From: Sue Howell
Sent: 24 August 2016 12:00
To: Planning.Responses
Cc: Simon Davis
Subject: FW: Planning Consultation on: EG/57/16/PL

Comment from Greenspace

APPLICATION EG/57/16/PL

Description of Works: Medical centre with pharmacy retail unit & other
ancillary uses together with access onto
Barnham Road & associated car parking. This
application is a Departure from the Development
Plan.

Client
The Croft Medical Centre
Project
The Croft Medical Centre, Barnham
Title
Landscape details sheet 1 of 2

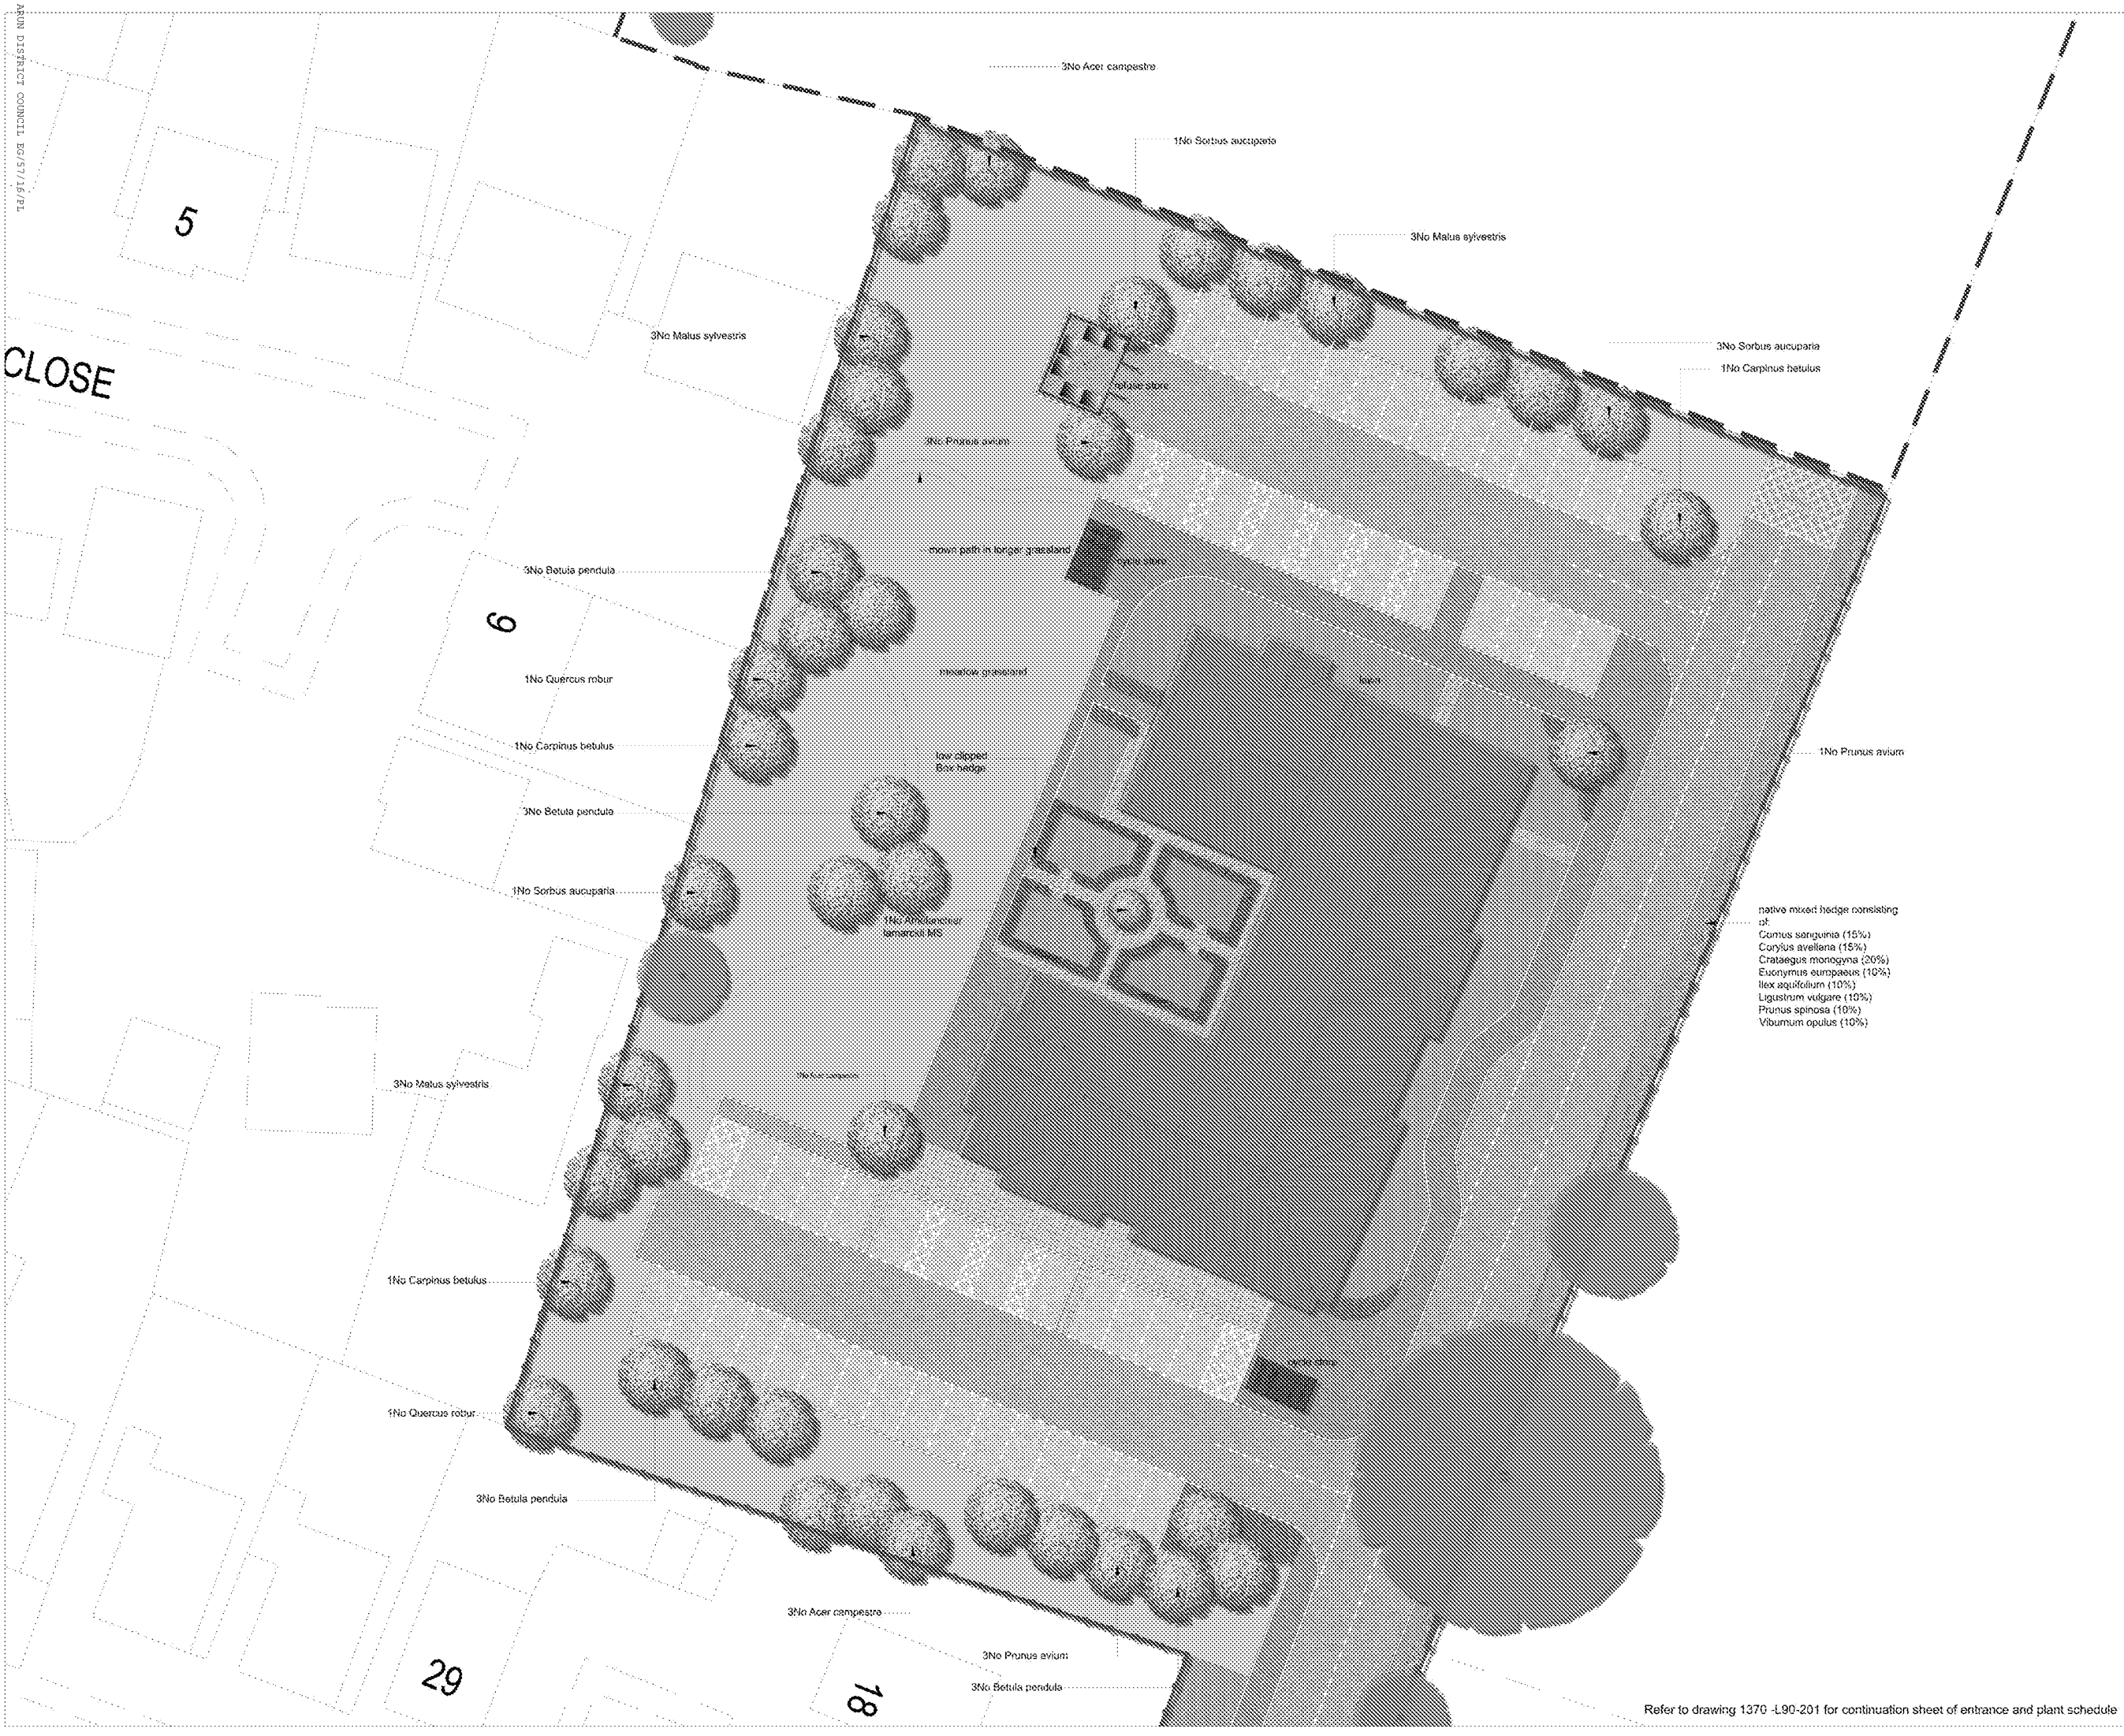
Existing trees and hedgerows along boundaries where established must be protected and retained and would require further planting to infill if found to be required. New tree and hedge planting would be required to infill sections where there are gaps and missing sections. This is particularly required to the southern and western boundaries of the site, where the proposals border neighbouring properties.

A full landscape scheme should be submitted for approval, detailing species choice, position, densities and size at time of planting. This should be plotted in plan and list form and in relation to the trees and vegetation to be retained so that a clear picture of the proposals can be seen. These details are required to assure the adjacent properties privacy is maintained and the surrounding landscape is uncompromised. The landscape details dwg L90-200 and dwg L90-201 shows this in some detail but in indicative form only, further plan detail with annotation would be required. The privacy and views of the adjacent existing properties have the potential to be compromised by the proposals and full consideration of mitigation planting to offset the impact should be considered within the landscape design.

TITLE			
Tree Protection Plan Eastergate			
SIZE	CAGE CODE	DWG NO	REV
A3		TP 2160/1704/TPP	
SCALE	1:200	22 Apr 2017	SHEET

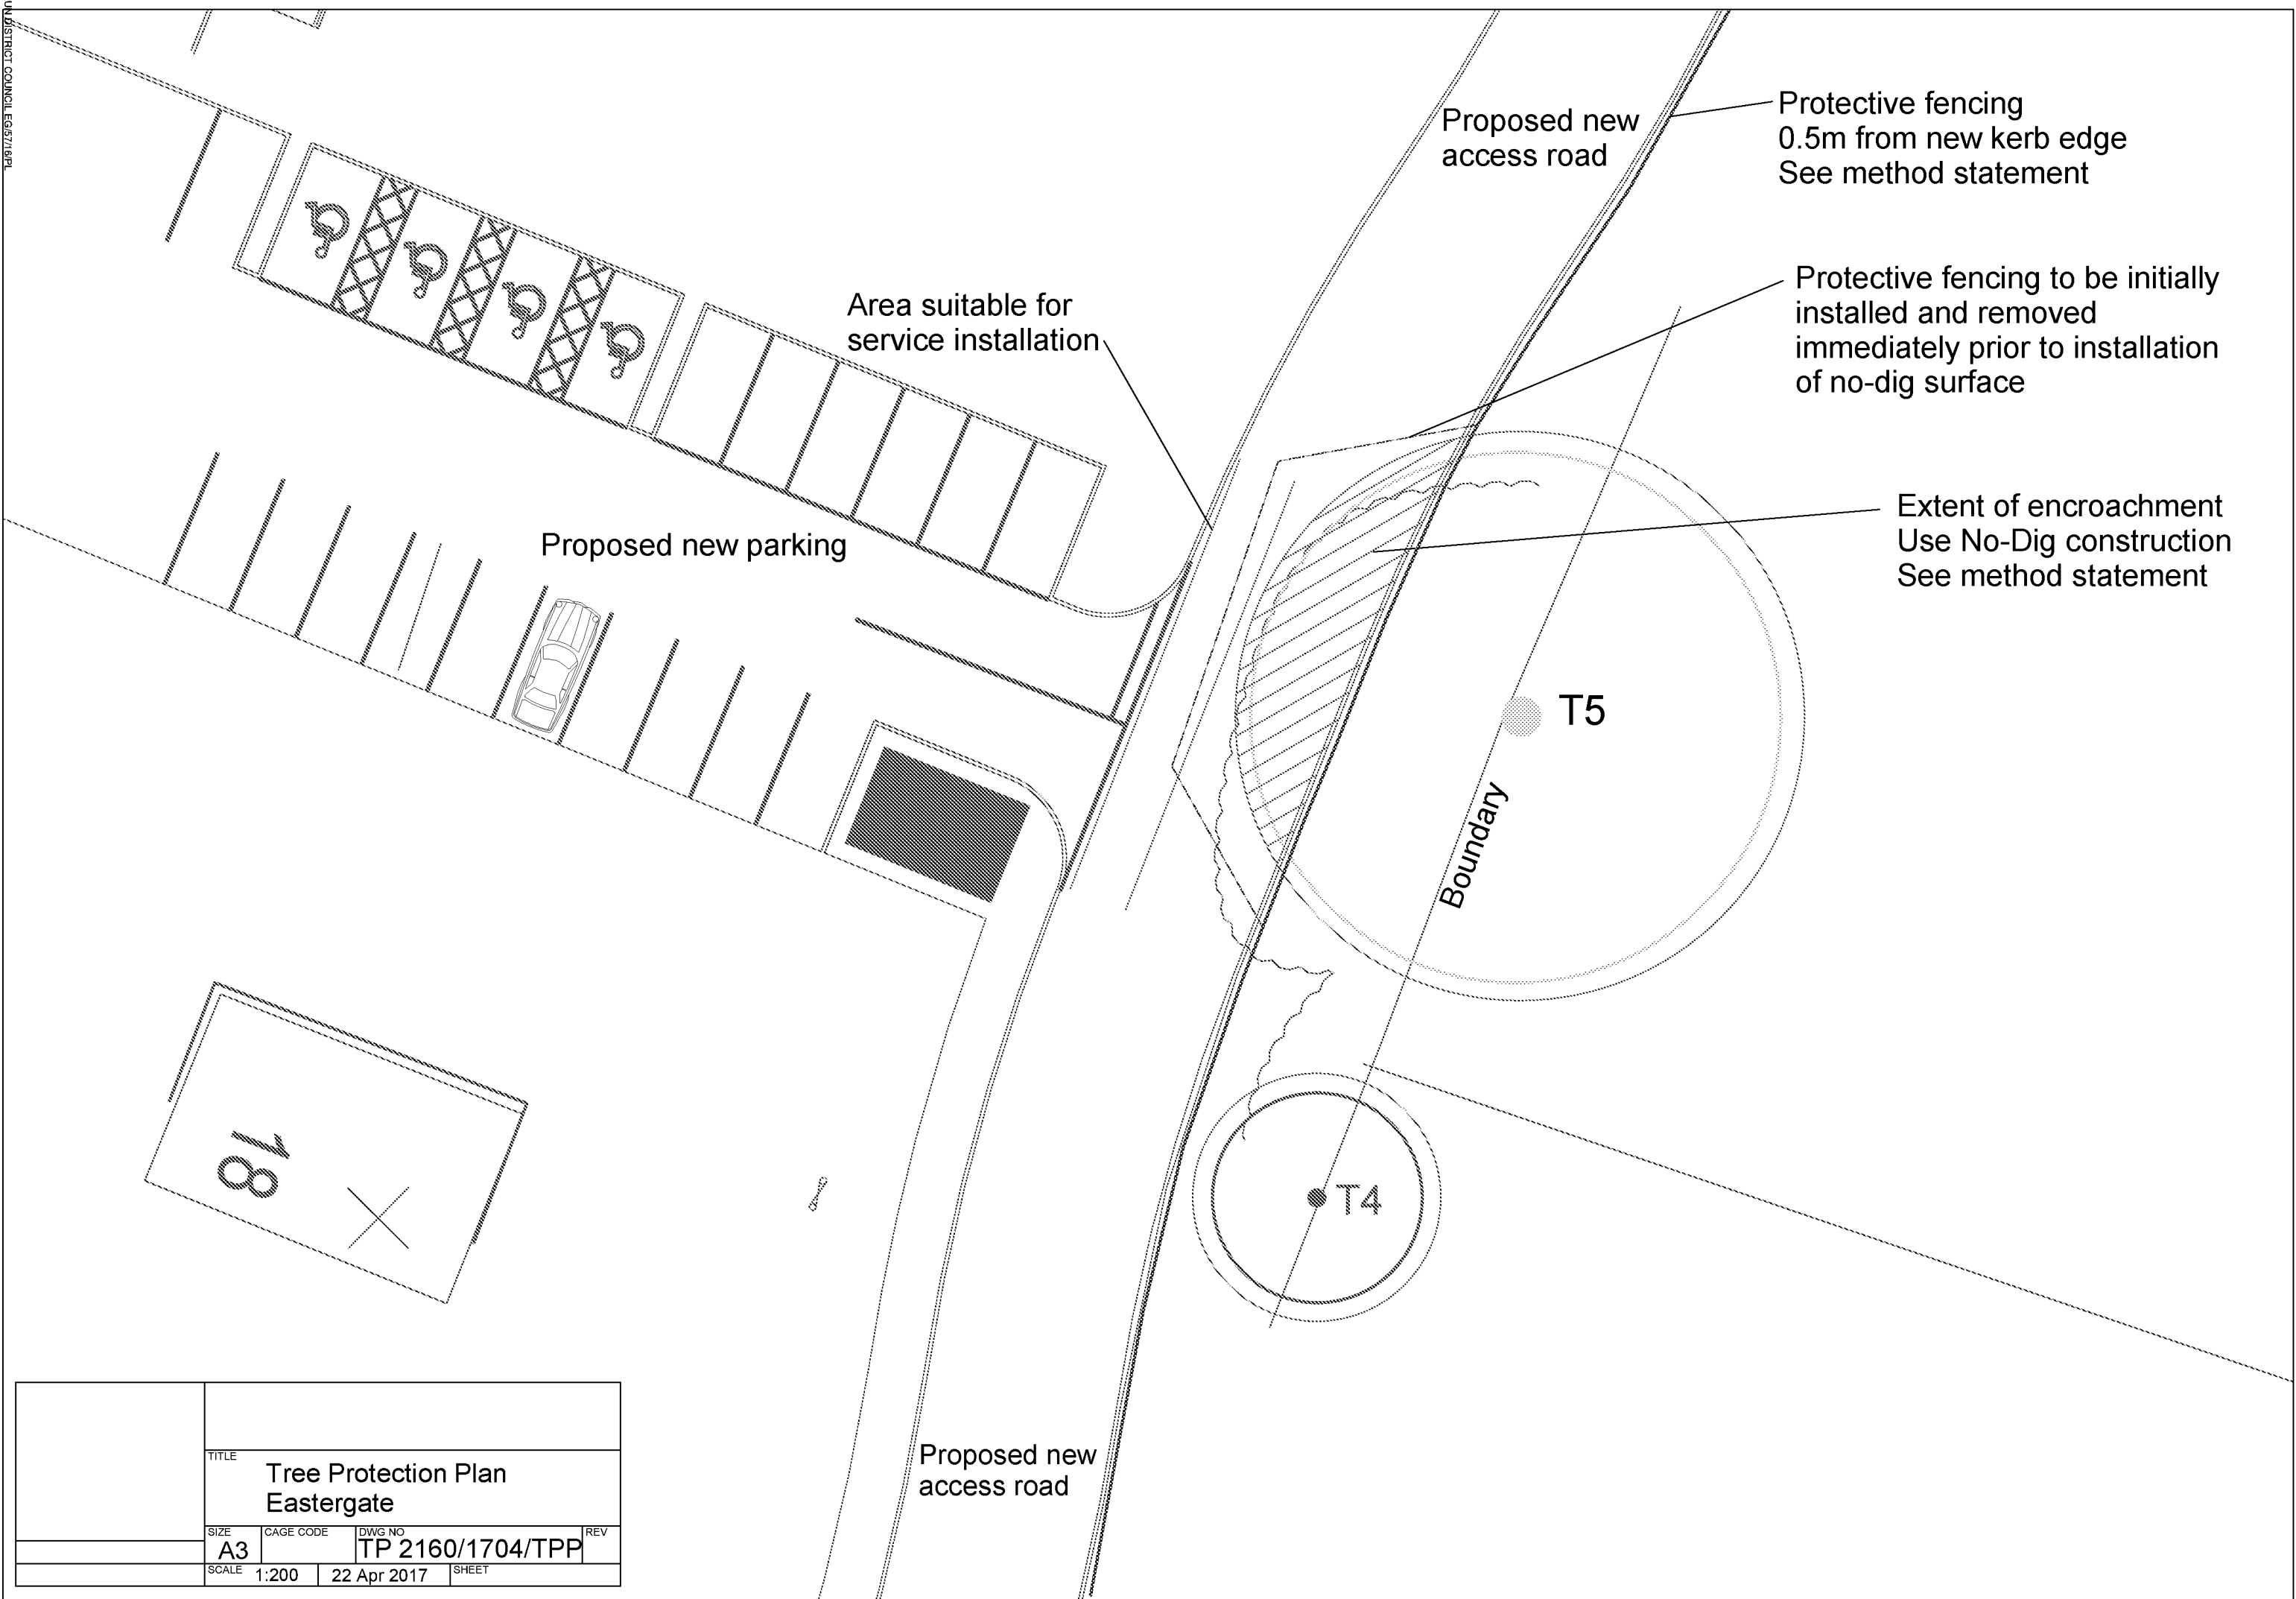
Arun District Councils Tree officer would need to be consulted regarding any proposed tree works. We note the tree cover to the periphery of the site which possess several existing significant trees including those located to the proposed access road and to the east of the site, which would require tree protection zones to be in place before any construction begins. This would be required for any retained trees including trees those whose root protection areas fall within the construction zone from neighbouring land; beyond the site boundary. This should be in accordance with BS 5837:2012 'Trees in relation to construction'
